COUNCIL REFERENCE: 3A10/1003SW (D13/321376)
CONTACT PERSON: Matthew Kidd
YOUR REF: MP09_0088

**Shoalhaven Water Response – Submissions for Concept Plan Approval –
Mixed Use Subdivision, West Culburra (MP09_0088)**

In reference to your correspondence dated 10/12/2013, Shoalhaven Water provide the following response to the applicants submission -

WEST CULBURRA MIXED USE CONCEPT PLAN

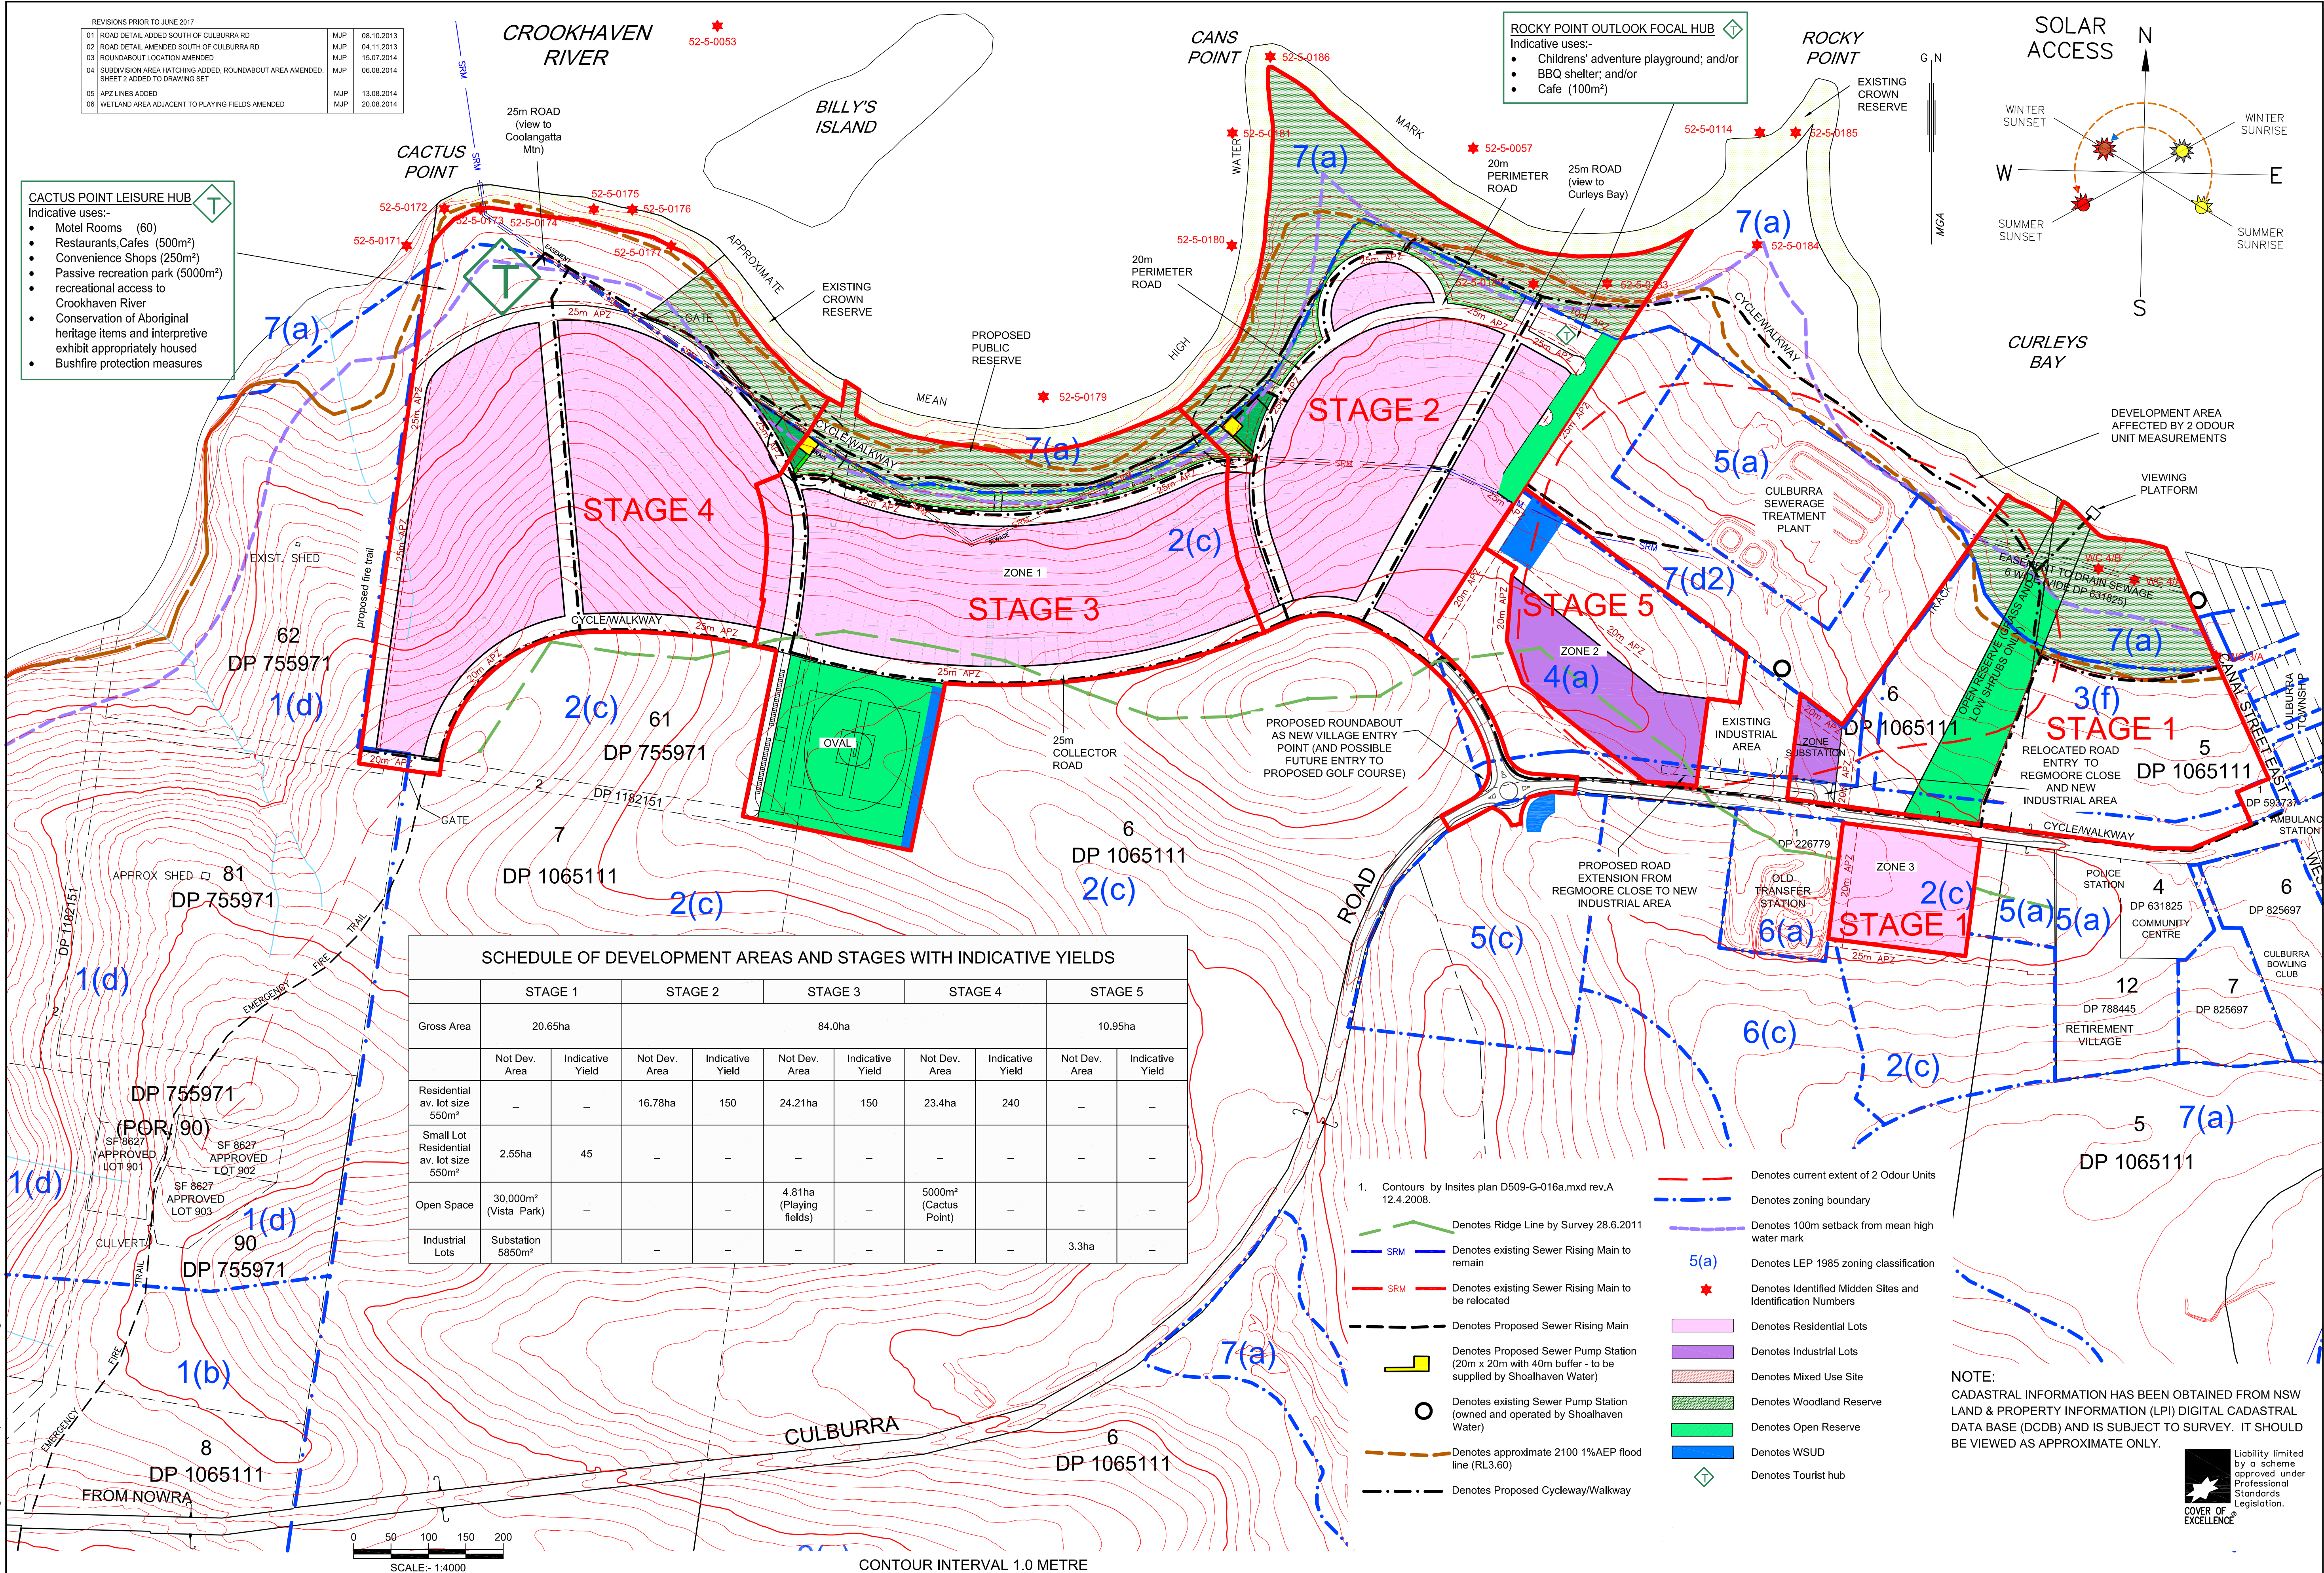
- An existing 225mm DICL & 375mm DICL sewer rising main (SRM) is located within an easement within lot 6 DP 1065111, Shoalhaven Water will not permit the construction of any structure within the boundary of the easement or within the zone of influence of the existing pipe. The applicant shall consider the location of the existing 225mm SRM and easement during design. Any proposed relocation of this main shall be determined after detailed consultation with Shoalhaven Water.

- An existing 375mm DICL sewer rising main (SRM) is located within an easement within lot 5 DP 1065111, Shoalhaven Water will not permit the construction of any structure within the boundary of the easement or within the zone of influence of the existing pipe. The applicant shall consider the location of the existing 375mm SRM and easement during design. Any proposed relocation of this main shall be determined after detailed consultation with Shoalhaven Water.
